City of Albuquerque Stormwater Construction Site Inspection Report

| ESC File No. | K09E050 | Project Name: | Bluesky Distributing Tract 9B | | |
| NPDES Id. No. | NMR10051D | Location: | Bluewater Rd and Daytona Rd | | |

SEDIMENTATION/SILT FENCE WITH WIRE SUPPORT

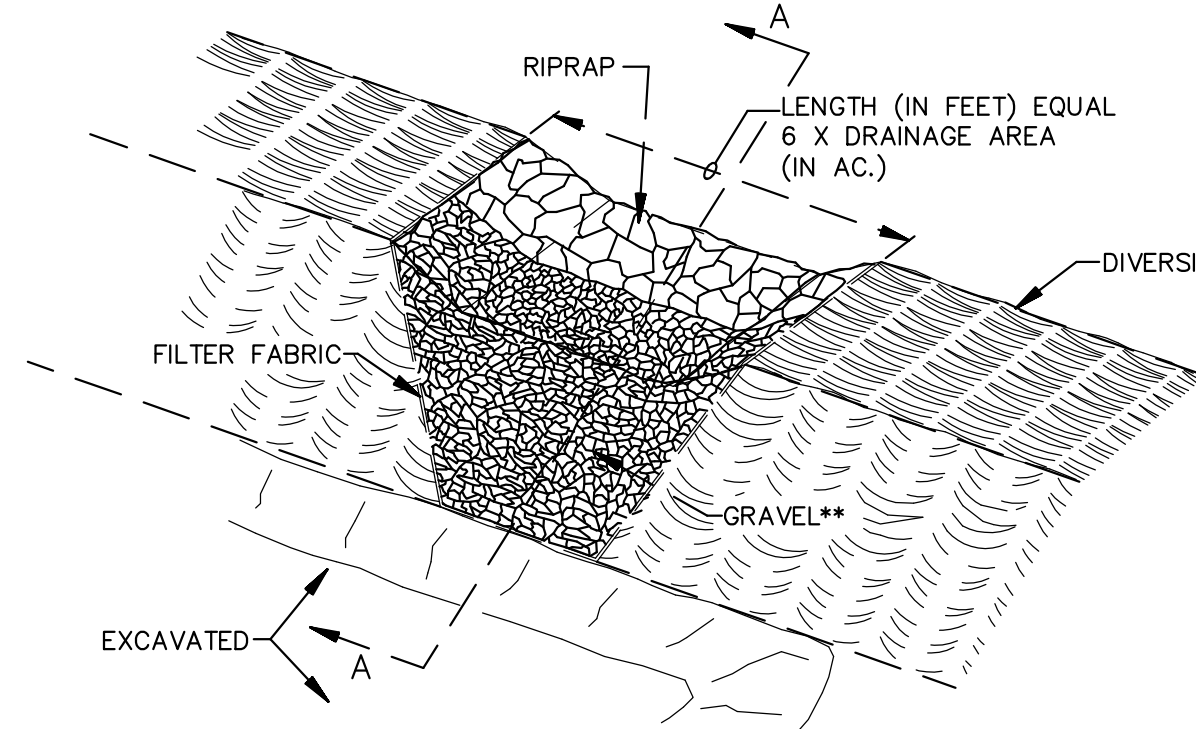
| Item Number | Deficiency/ Corrective Action | | | |
|-------------|--|-----|--|-----------|
| 2 | BMPs were damaged or collapsed. Multiple sections of the perimeter silt fence on the west and south edges of the properties need maintenance and/or repair. Required mitigation: You must ensure all stormwater controls are maintained and remain in effective operating condition during permit coverage and are protected from activities that would reduce their effectiveness per CGP 2.1.4. | | | |
